# West Burton C Open Hearing (OH) and Issue Specific Hearing (ISH) Summary of oral responses

## **2 ISSUE SPECIFIC HEARING – 22 JANUARY 2020 10:00**

**EDF Energy (Thermal Generation) Limited (“EDF” or the “Applicant”)**

Figure 2. HGV Designated Route Plan (Proposed Development Construction)

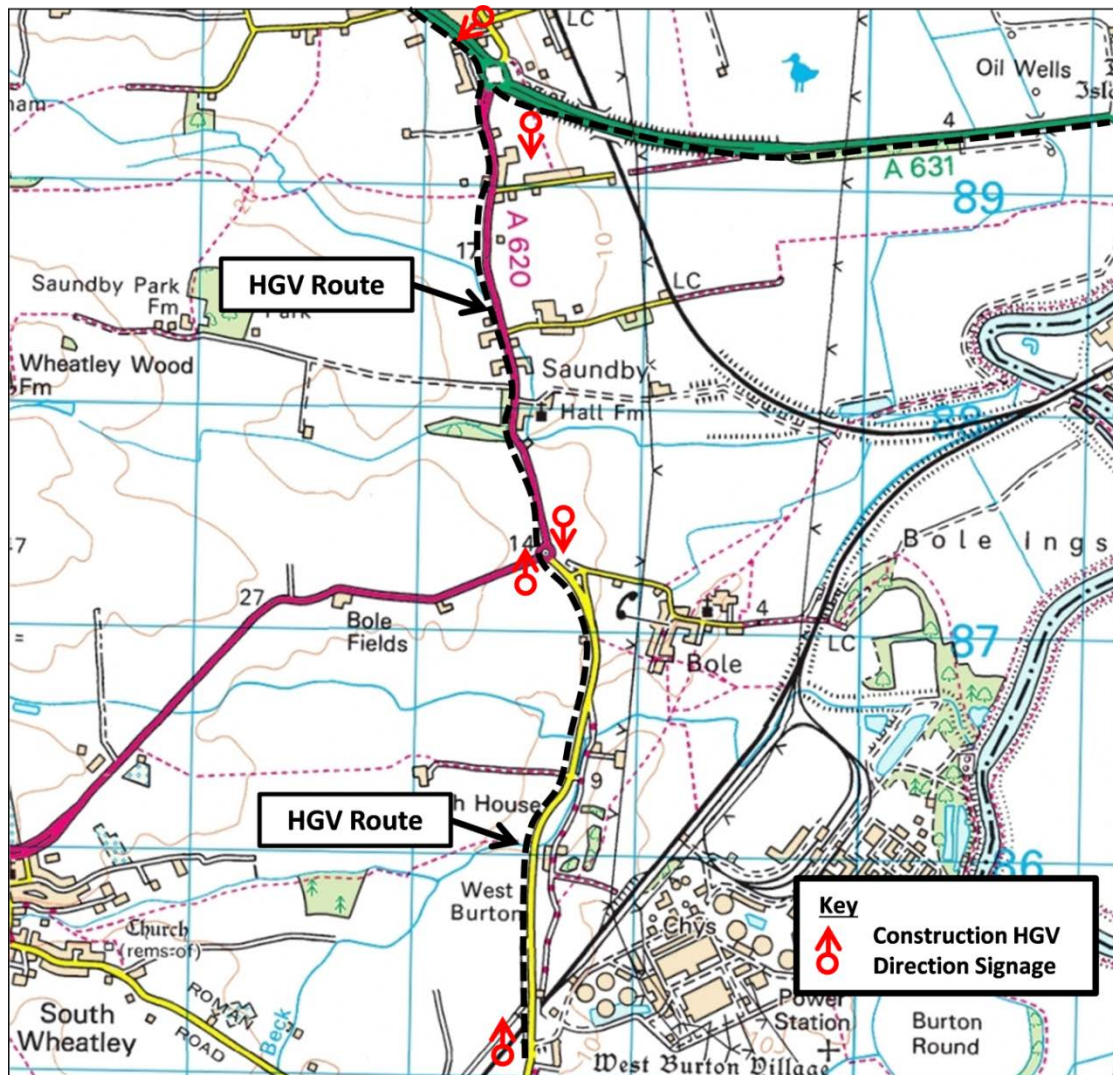
The Applicant agreed to confirm in writing what volume of soil could be accommodated on site and where.
2.3	<b>Construction traffic routing and management-</b> Applicant to set out how construction traffic would be routed and managed to avoid HGV travel through villages and HGV parking/waiting on the public highway and how this would be secured;	<p>The Applicant explained that these matters are addressed in the Framework Construction Traffic Management Plan (FCTMP) secured by Requirement 8. A Construction Routing Traffic Plan (CRTP) will be secured in accordance with the FCTMP and Requirement 8. Section 2 in the FCTMP deals with this matter and the proposed measures for the designated route.</p> <p>Dr Lowe confirmed that the designated route for HGVs and construction vehicles is set out in the FCTMP. This route was identified following discussion with the local authorities. The CRTP will confirm the route and specify that all deliveries will follow that route. The CRTP, which would need to be approved by the local authorities, will also include measures to control hours of operation, signage, and other matters. The Applicant will include within its contracts conditions to ensure compliance with the CRTP. This may include compliance with anti-social behaviour policies and restrictions on using the layby at Bole, for example. Other projects have previously adopted a 'yellow card, red card' policy for drivers, whereby drivers may be precluded from working on the project if they breach the conditions of their contract. The Applicant will also ensure that there is a dedicated person for members of the public to contact with any traffic-related concerns.</p> <p>In relation to parking on-site, the Applicant confirmed that there will be parking on-site for workers and HGV deliveries. The Applicant does not envisage offering 24 hour parking for HGVs because that would create difficulties in relation to health &amp; safety, security and providing appropriate amenities. The Applicant will seek to ensure that there is no HGV parking on the roadway outside of delivery hours by including appropriate conditions in its contracts. The Applicant will, however, monitor this issue and put further measures in place, if appropriate.</p> <p>The ExA queried how these measures were to be secured.</p>

<p>The Applicant confirmed that it would update the FCTMP to explain in more detail what measures would be put in place.</p> <p>Mr Coomber noted that he would like further information in relation to how traffic relating to this project will be dealt with in conjunction with traffic relating to other nearby projects, including a solar farm.</p> <p>Dr Lowe on behalf of the Applicant explained that a cumulative assessment was undertaken as part of the EIA. The Applicant agreed with the local authorities which other schemes should be included as part of that assessment. All public information available as to anticipated HGV usage in relation to those schemes was incorporated into the baseline data set for that assessment.</p> <p>The Applicant noted that it would expect other schemes coming forward to also have a Construction Traffic Management Plan and that it was the local authorities' role to manage cumulative construction traffic using those plans. The Applicant also explained that the assessment in relation to this scheme was undertaken on a worst-case basis because it assumed that all cumulative development would come forward at the same time, which is unlikely to be the case. There is no way to know which of the cumulative schemes assessed will actually come forward and when. Any future schemes coming forward would be assessed at the appropriate time, when further details are known.</p> <p>Bassetlaw District Council confirmed that it had not received a planning application for the solar farm referred to by Mr Coomber.</p> <p>West Lindsey District Council and Bassetlaw District Council confirmed that they were comfortable with this approach.</p>

Figure 2: Landscape and Biodiversity Enhancement Proposals

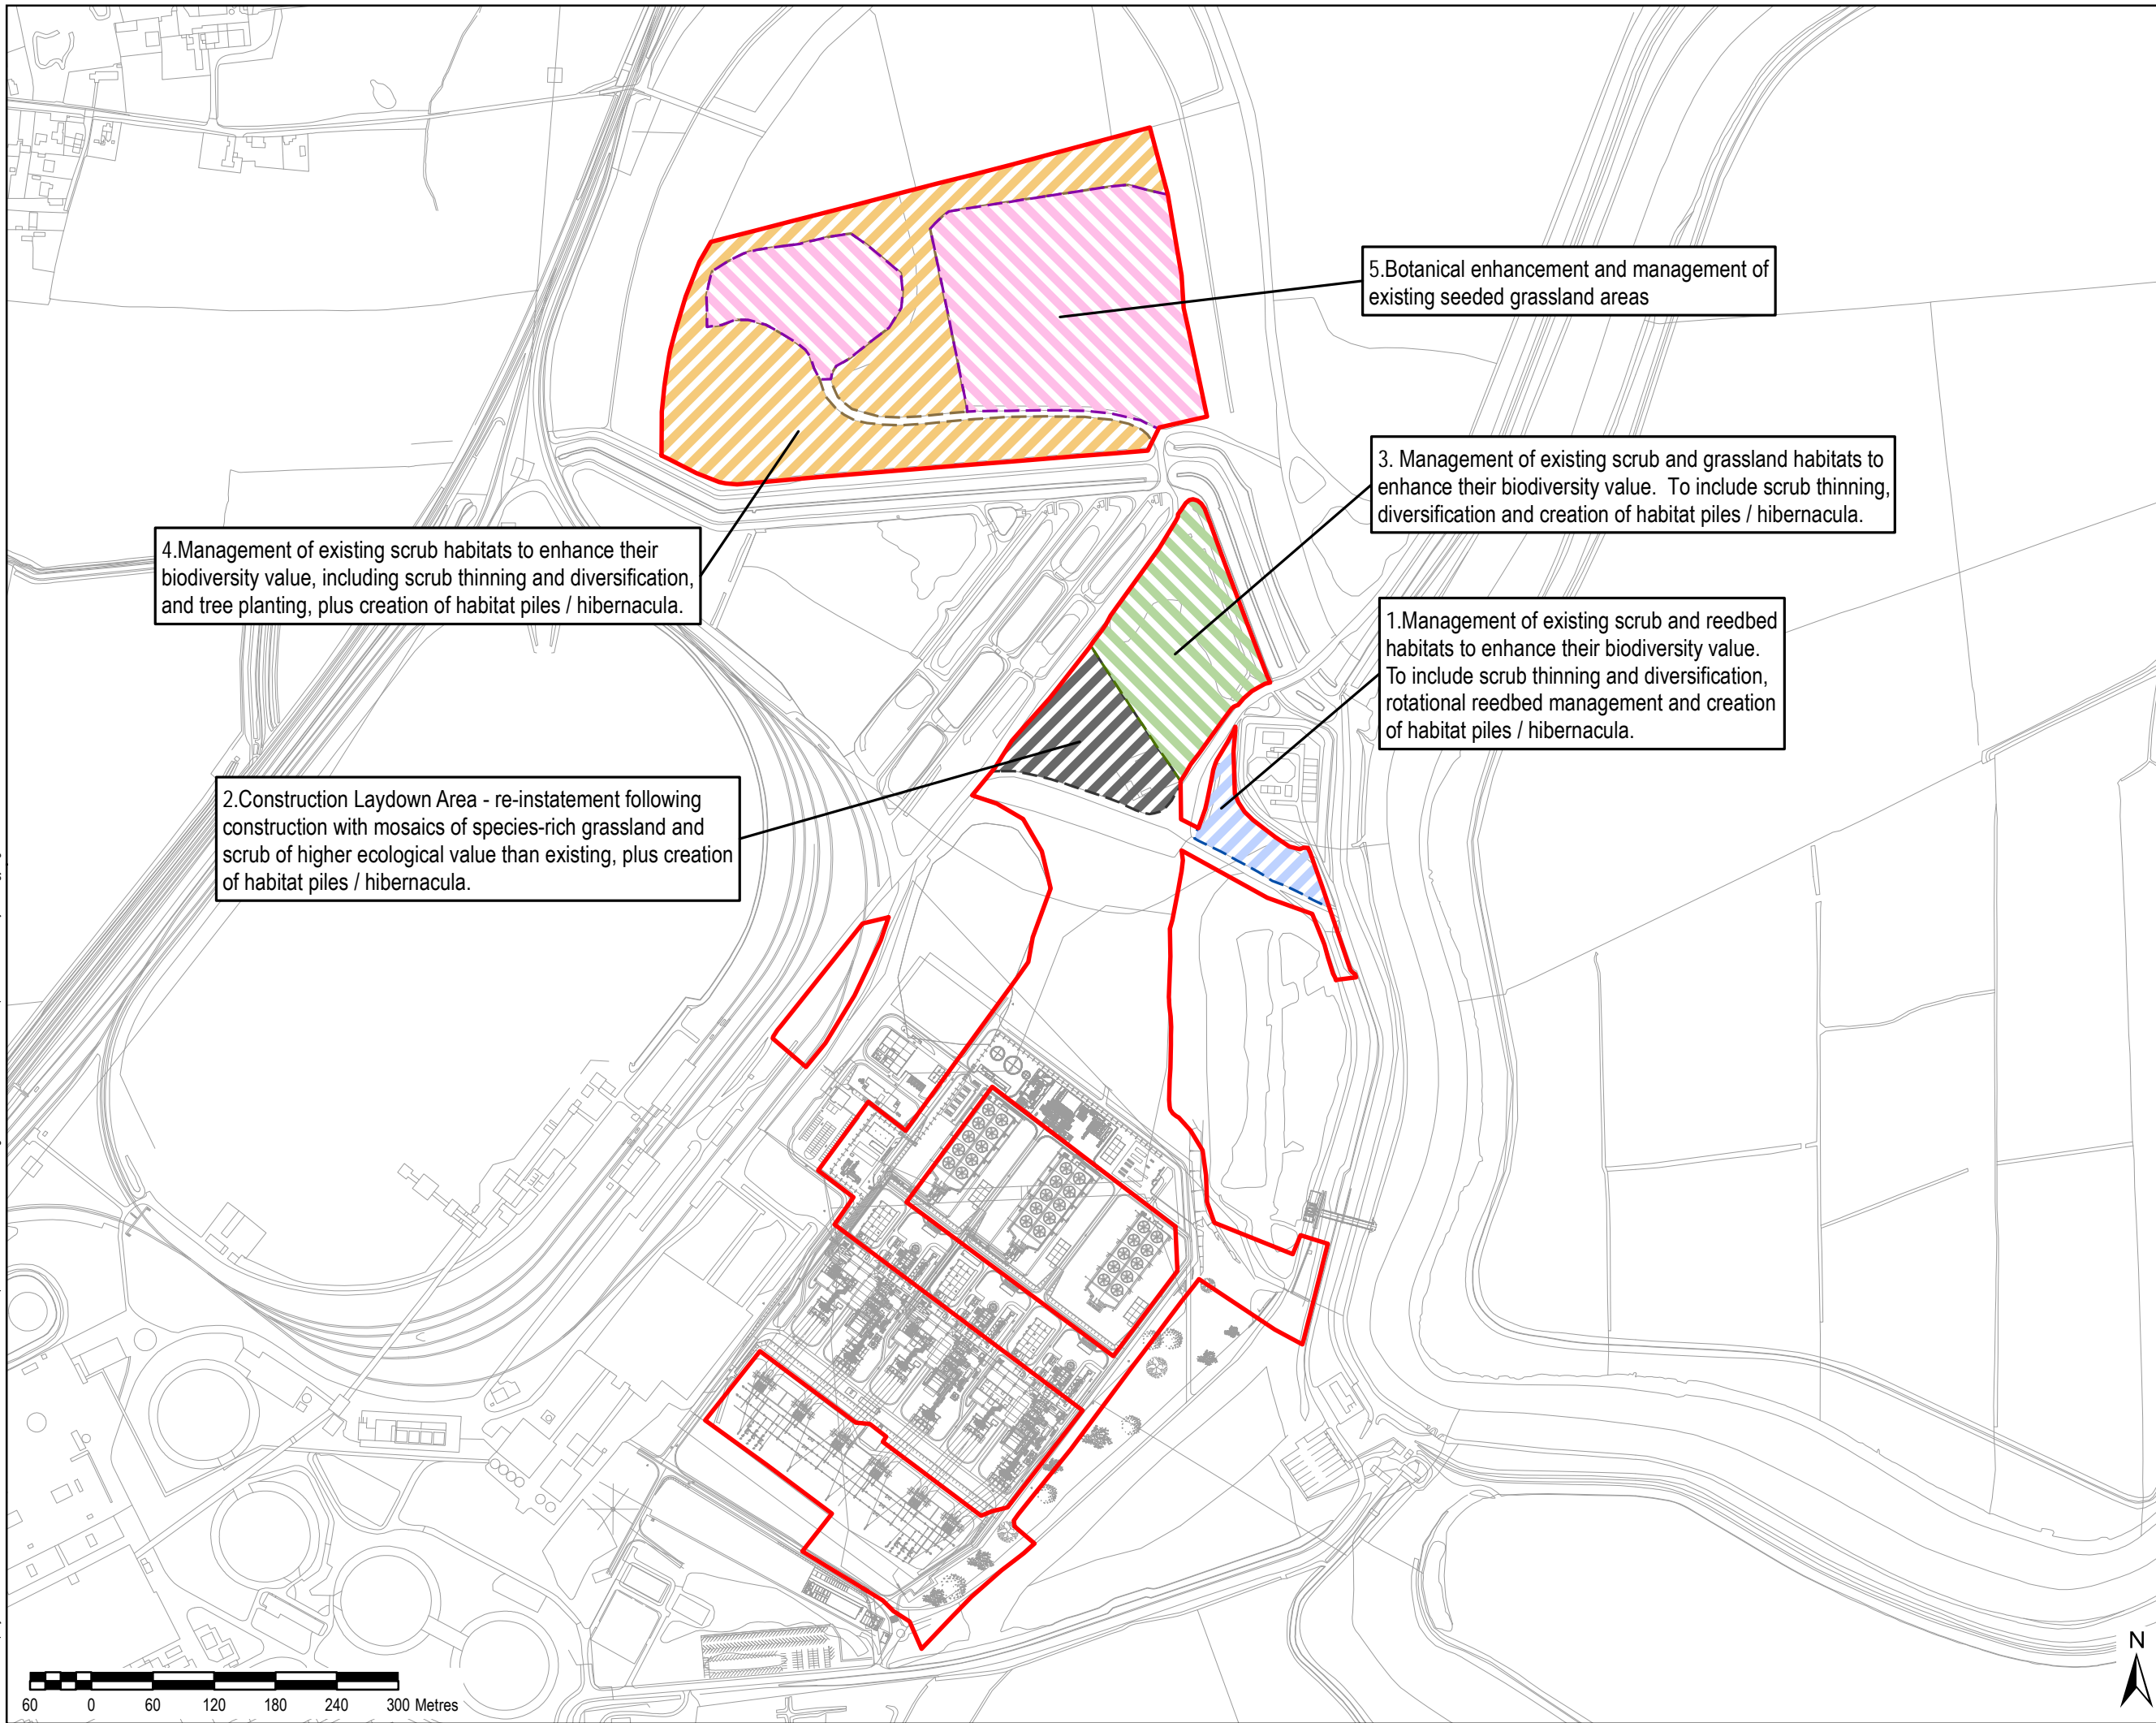
<b>2.1.5</b>	Explain how the habitat within Area 5 would be enhanced.	<p>Dr Lowe explained that the LBMEP sets out a number of enhancement measures that are relevant to the grassland in Area 5. Dr Lowe noted that Area 5 is the area that the Wildlife Trust were concerned about in relation to previous enhancements that should be reflected in the baseline condition. Dr Lowe confirmed that the Applicant was not reliant on enhancements to Area 5 in order to achieve a net gain.</p> <p>The ExA commented that he had not seen any formal representations from the Wildlife Trust. [The Wildlife Trust were not in attendance at the hearing.]</p> <p>The Applicant confirmed that it was in dialogue with the Wildlife Trust in relation to an advanced draft Statement of Common Ground. The Applicant noted that it hopes to be in a position to submit an agreed Statement of Common Ground for Deadline 4.</p>
<b>2.1.6</b>	Biodiversity mitigation- Nottinghamshire County Council to explain any	Nottinghamshire County Council were not in attendance.
